Project name: TAMLIN ROAD RV STORAGE

TAMLIN ROAD RV STORAGE		O&M MANUAL – FACILITIES MAP		SHEET 3 OF 10		JOB NO. 25134.00	
H-SCALE		V-SCALE		DATE		DESIGNED BY	
1"=50'		N/A		01/17/20		NQJ	
						NQJ	
						NQJ	
						CHECKED BY

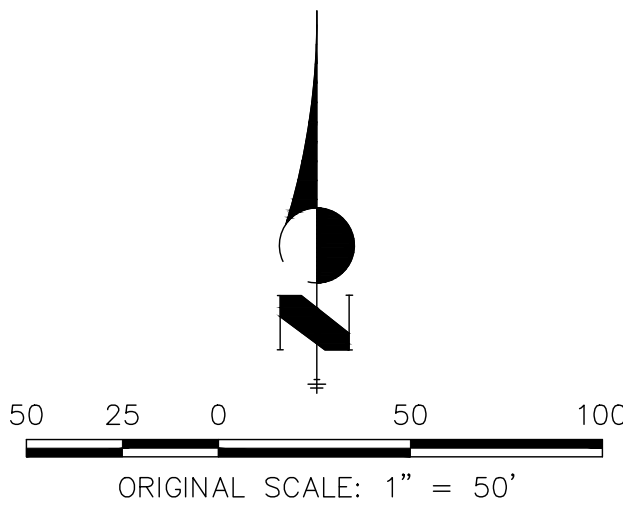
Remove. There is only one Pond proposed at this time

JR Response: Addressed.
